**SOIL/SITE EVALUATION
 for ON-SITE WASTEWATER SYSTEM**

Owner: *Bryan Maloney* Applicant: *Seth Miller*
 Address: *370 Cypress Church rd* Date Evaluated: *2-26-21*
 Proposed Facility: *SFD* Design Flow (.1949): *480 GPD*
 Location of Site: Property Recorded:
 Water Supply: Public Individual Well Spring Other
 Evaluation Method: Auger Boring Pit Cut
 Type of Wastewater: Sewage Industrial Process Mixed

SURVEY FOR
BRYAN THOMAS MALONEY
& WIFE
JORDAN DAVIS MALONEY
RIZZO LAND
JOHNSONVILLE TOWNSHIP, HARNETT COUNTY,
NORTH CAROLINA

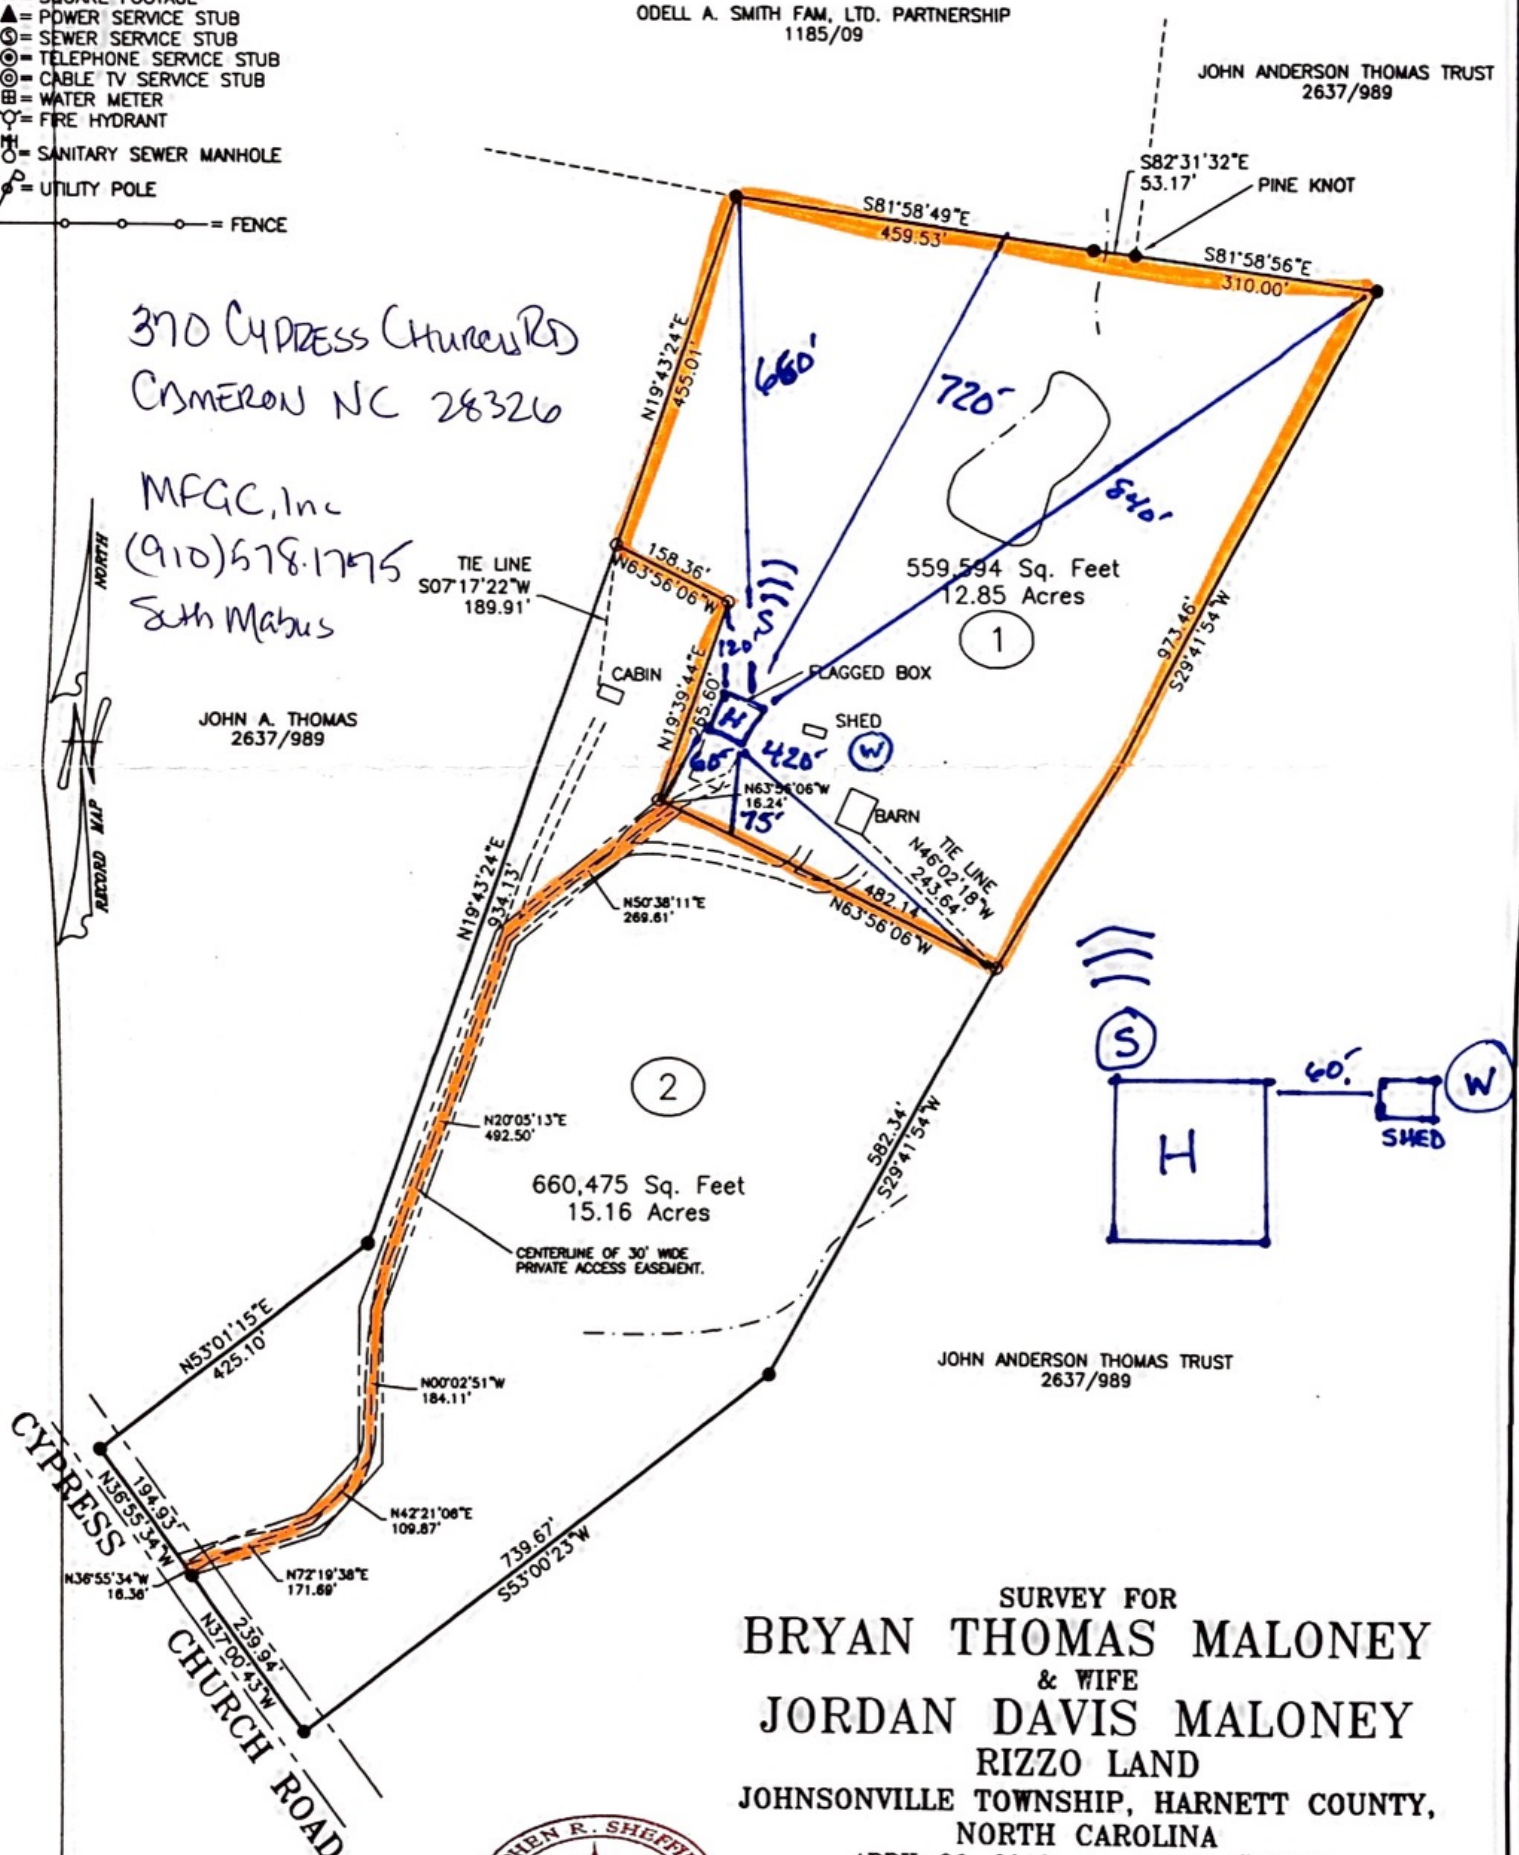
2-26-21
 - Get LSS TO Eval
 For Suitable Area
 - Get Prop Irons +
 Prop Line Located
